HE.1.2 North Kesteven District Council Historic England

ES Chapter 10 [APP-063] includes a setting assessment of the Grade I listed Kyme Tower and it is concluded at paragraph 10.5.22 that there would be no harm to its significance. NKDC in their LIR [REP1-033] disagree, stating at paragraph 16.26 that 'no views of the tower, or away from the tower, should be classed as "incidental"' and they assign a negative impact on its significance.

ii) Can Historic England provide comment on both the Applicant's and NKDCs assessment of harm to Kyme Tower?

CONTEXT BASELINE VIEWPOINT 19

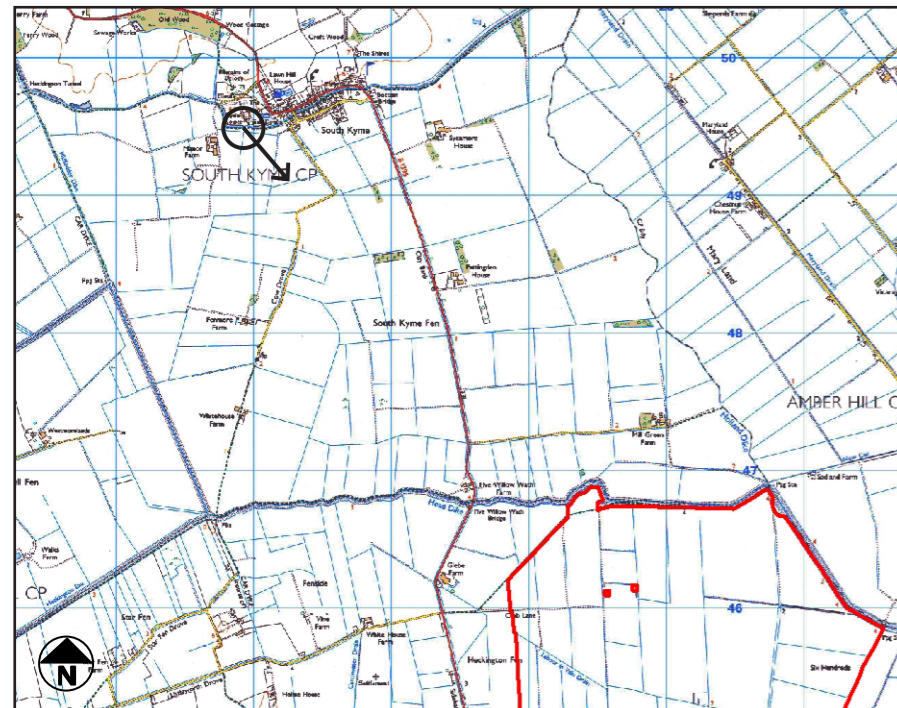
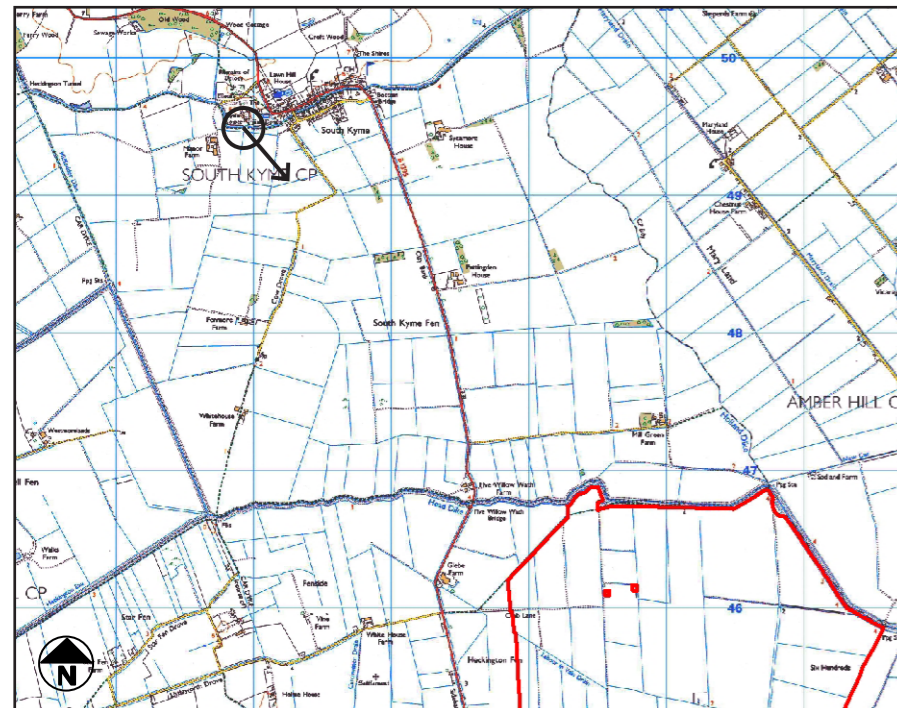
Views from south of the Heckington Eau, within and across the proposed solar development will still have the capacity to contribute to significance, but arguably to a much lesser degree. The applicant assesses views affected by the development as incidental whilst the local planning authority stresses that they make a contribution to significance and can hence be regarded as entailing a degree of harm. Such harm can occur via loss of agrarian appearance / obstruction of views through the development. Impacts of the development upon the significance of the Tower would appear to fall below the level of a reportable significant effect in terms of Environmental Impact Assessment. From a planning policy perspective in which all harm to the significance of designated assets requires clear and convincing justification and to be set against public benefits, a low level of less than substantial harm might still be identified and taken into the ExA's consideration.
